From: Kate Giddings
Sent: 24 June 2019 15:03
To: 'Deborah Osborne'
Cc: Juan Baeza
Subject: RE: WA/23/19/DOC

Discharge of Lighting conditions WA/23/19/DOC Fairmeads Farm, Binsted Lane, Binsted, BN18 0LQ

RA / 674 / 100 D

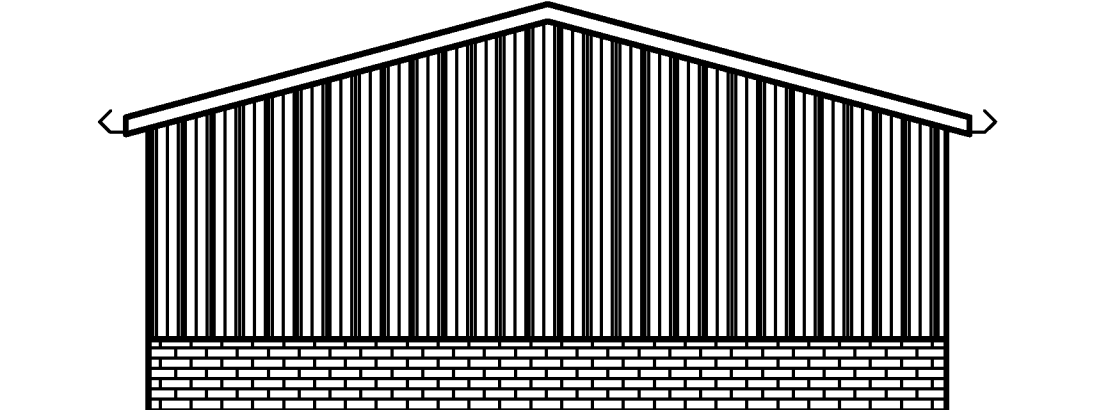
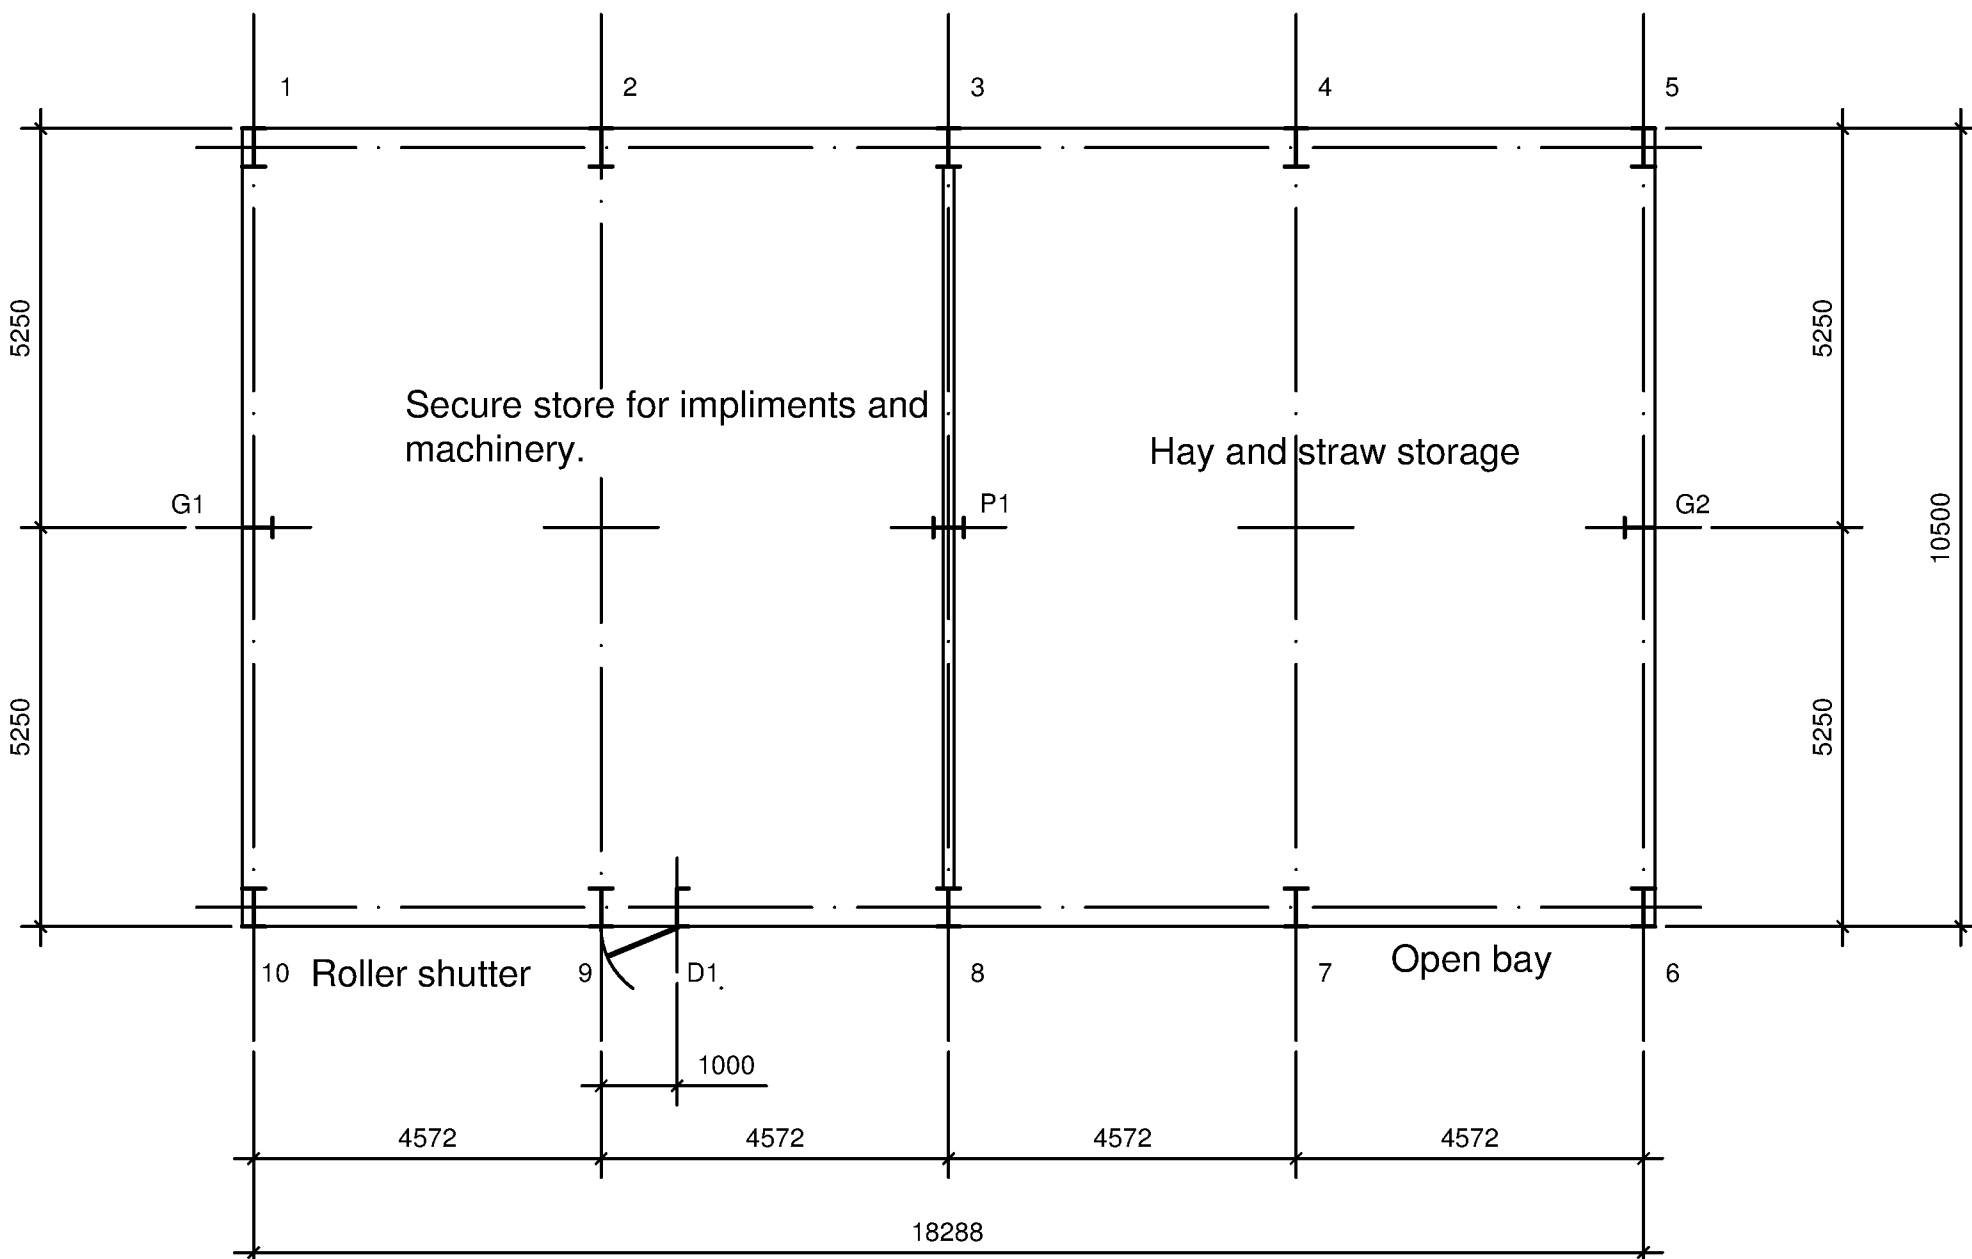
Type of appliance: This is a wall-wash downlighter. It was specifically chosen not to project light outwards away from the immediate area of the wall to which it is mounted.

Height of fixture: The unit will be mounted approx 2.3m above the ground.

Position of fixture: The unit will be positioned on the side wall (south elevation) of the building above the personnel door as detailed in drawing RA/674/100D

Illumination levels: 130 Lumens

Light spillage: The downlighter limits direct projected light to within around 20° of vertical. Any indirect light spillage is kept well below horizontal. This square version of the light was chosen as a result of online research into best practice of avoiding light pollution and light spillage. It was recommended as a "good example of fully shielded light" in the lighting guide below. If you are aware of any alternative lights offering greater level of compliance, please let us know and we will happily consider this instead.

The light would be on a PIR sensor to minimise it's use.

The information you have provided seems satisfactory, therefore this Department has no further comments to make regarding this condition. Please note, however that this approval does not in any way indemnify against statutory nuisance action being taken in the event that substantiated complaints within the remit of the Environmental Protection Act (1990) are received. For further information, please contact the Department directly by telephoning **01903 737555**.
